RE: CANYON BREEZE SUB'D.; CITY PROJECT NO. 563981; MAP NO. F-21

Ms. Lisa Ann Manwill, P.E.
Hydrology
City of Albuquerque Hydrology Department
P.O. Box 1293
Albuquerque, NM 87103**RE: CANYON BREEZE SUBDIVISION (F21-D68) - ENGINEER'S
CERTIFICATION**

***RE: CANYON BREEZE SUBDIVISION (F21-D68). ENGINEER'S CERTIFICATION
FOR RELEASE OF FINANCIAL GUARANTEES. ENGINEER'S
CERTIFICATION DATED NOVEMBER 16, 1997.***

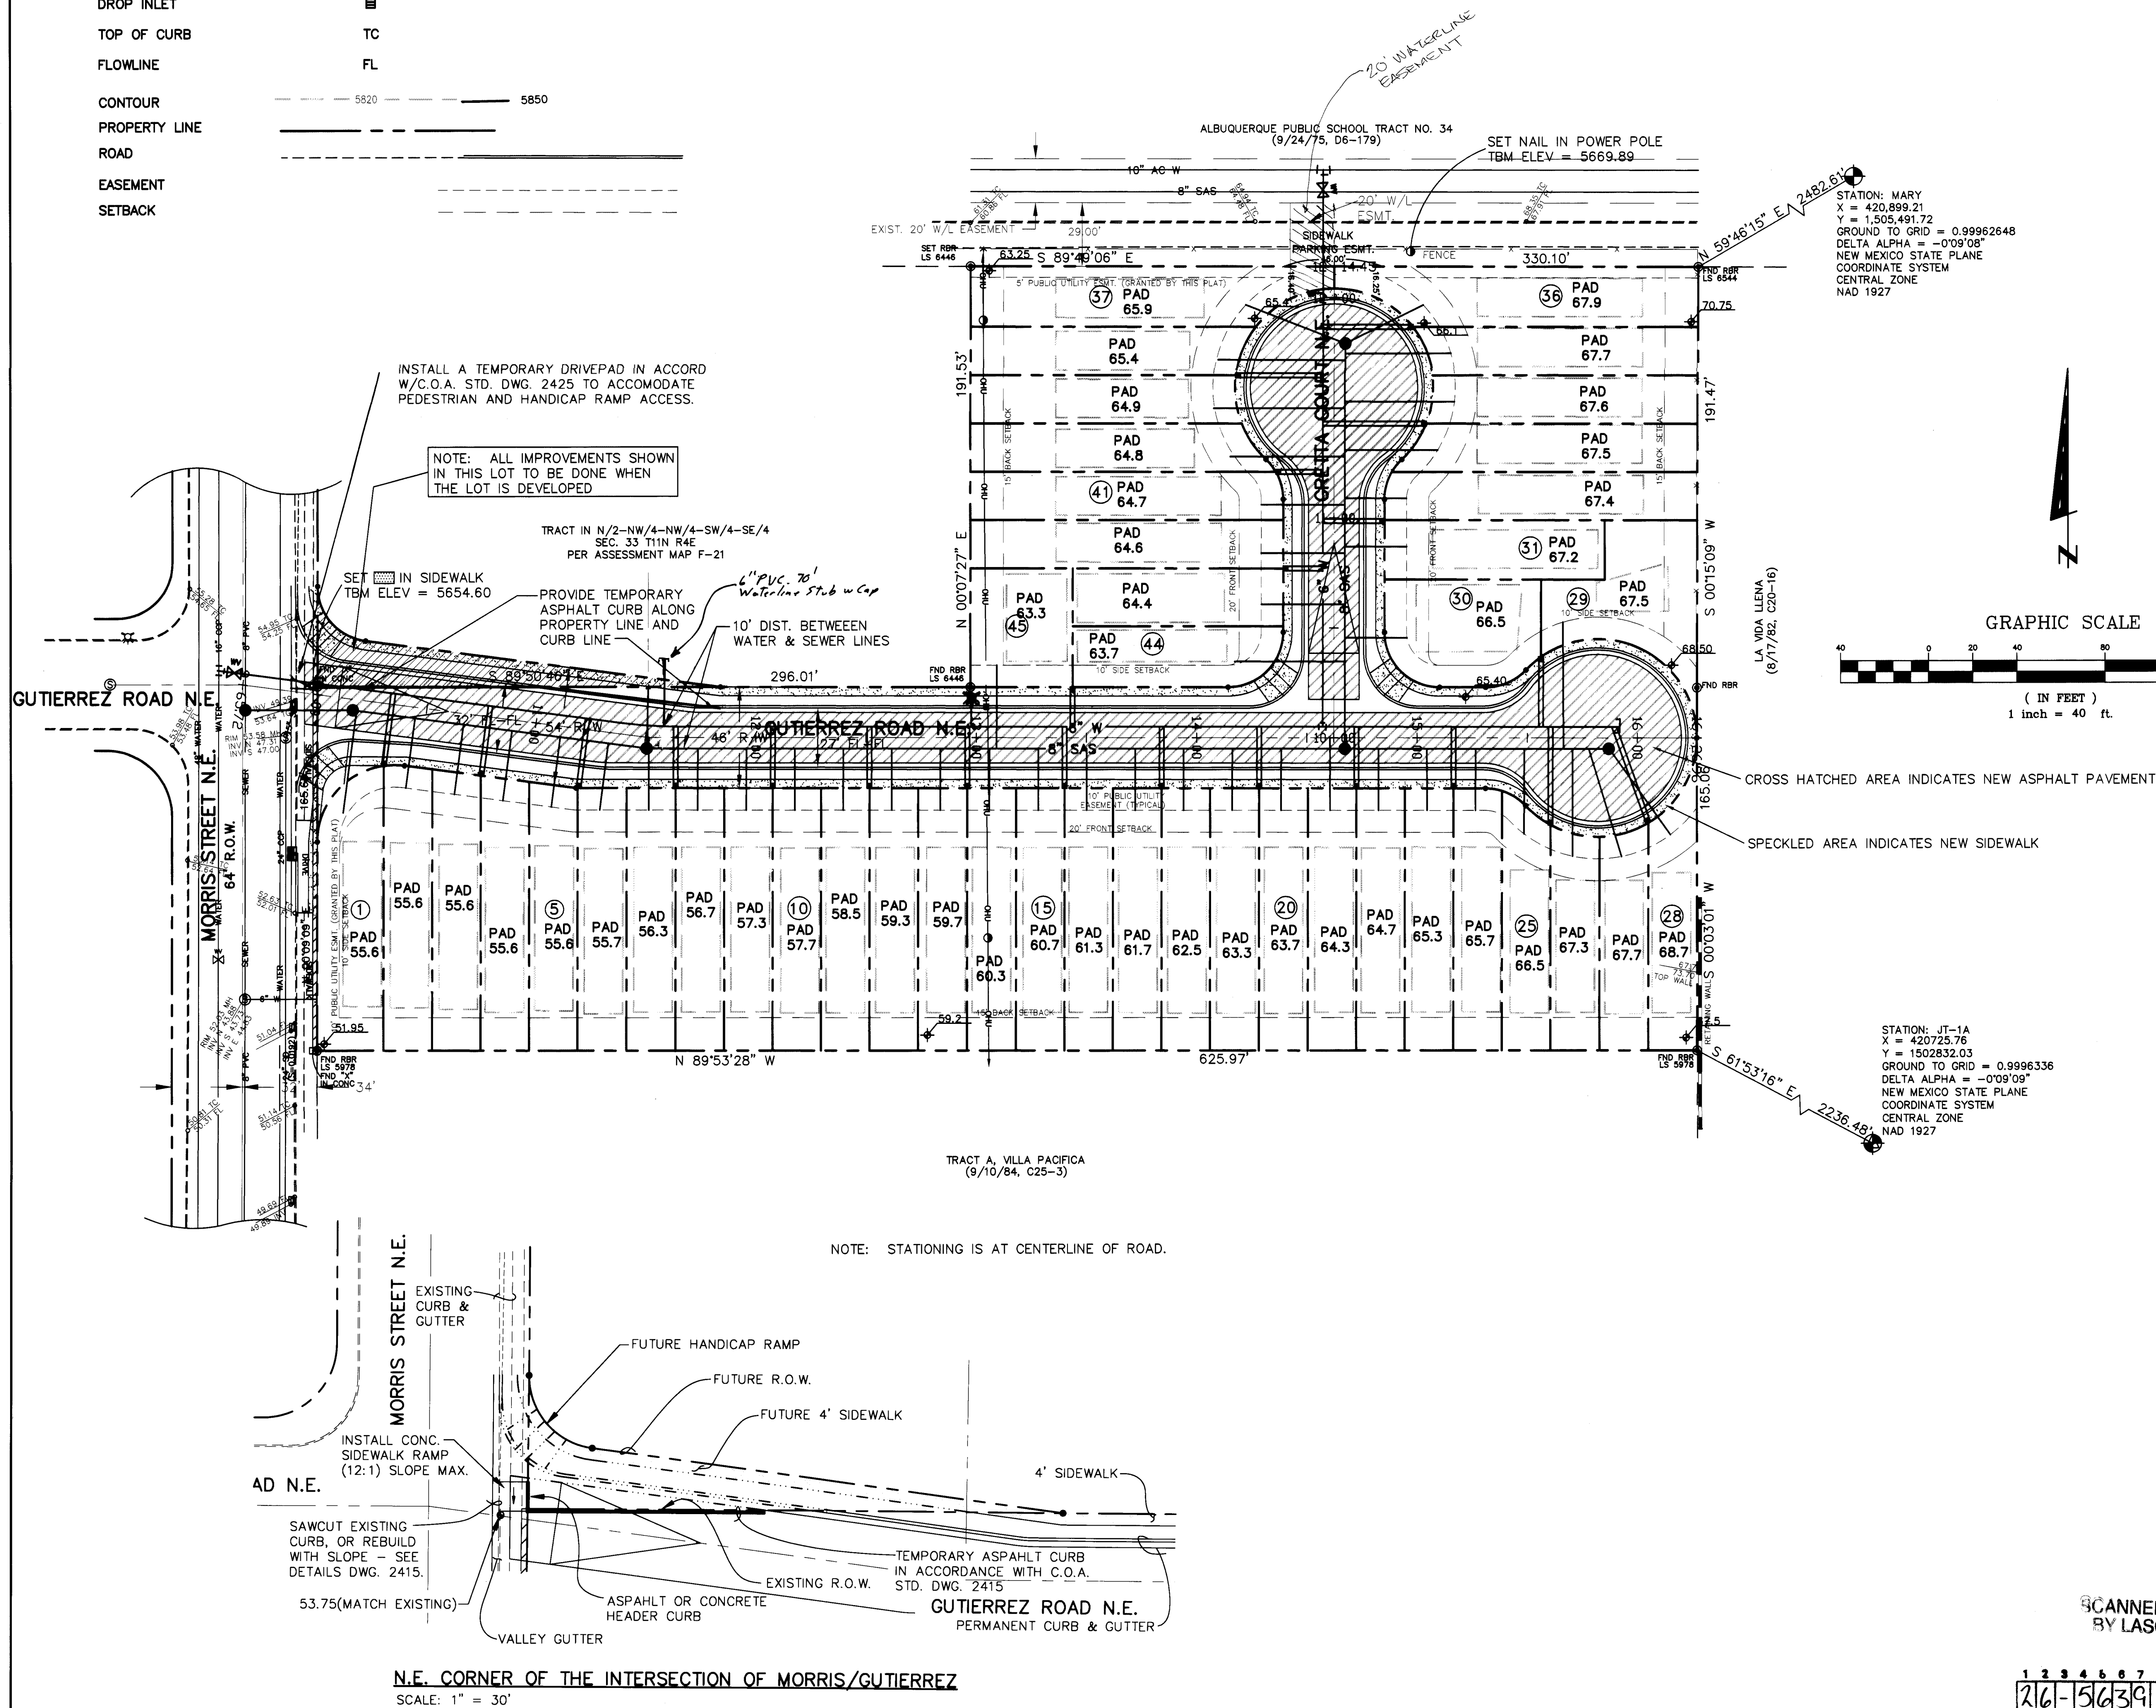
1. According to the approved grading plan (dated 1-16-97), the existing inlet and point of curvature at the northeast corner of Gutierrez and Morris are to be relocated. Prior to Release of Financial Guarantees, please complete all work associated with this project.

1. The existing inlet and point of curvature at the northeast corner of Gutierrez and Morris have been relocated. These improvements were handled by the Infrastructure Improvements Work Order and have been inspected and approved by the City's Construction Inspection Engineer.
